WEST SUSSEX COUNTY COUNCIL CONSULTATION

TO:	Arun District Council FAO: Simon Davies
FROM:	WSCC - Highways Authority
DATE:	9 December 2019
LOCATION:	Land North of Summer Lane Pagham PO21 4NG
SUBJECT:	P/70/19/RES Approval of reserved matters following outline consent P/58/15/OUT for 90 No. dwellings. Also seeking to address the terms of planning conditions 6 (Phasing), 8 (ecology), 9 (Surface Water), 12 (Vehicular Access), 15 (Parking), 18 (Travel Plan), 20 (Landscape Management), 24 (Parking Control), 25 (Dwelling Parking) and 26 (Materials). Amendment received.
DATE OF SITE VISIT:	n/a
RECOMMENDATION:	Advice
S106 CONTRIBUTION TOTAL:	n/a

DRAWING TITLE
Proposed Site Plan
90 Unit Scheme

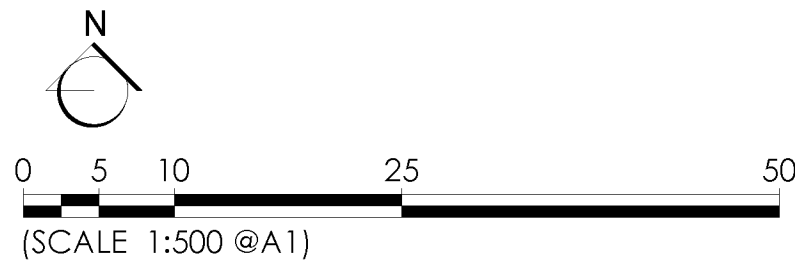
Road width leading to plots 24-29 – The revised layout shows access being to plots 25-29 as opposed to 24-29. The issue remains that the road leading to these plots is of insufficient width to enable two opposing vehicles to pass. It is accepted that this access road would be lightly trafficked and the need for two vehicles to pass is likely to be low. Nevertheless, there seems no reason why the road could not have been widened to at least 4.5 metres rather than retaining the 3.75 metres. The issue here will be one of convenience rather than safety, and any issues will not affect the operation of the public highway. Further consideration should be given to widening the road.

Refuse collection for plots 81-82 – The proposed arrangements are noted. Such matters should be confirmed with the Arun DC waste collection team.

Turning head near plot 65 – The intended use of this has been clarified and is accepted.

Length of driveways – As appropriate driveway lengths have been shortened.
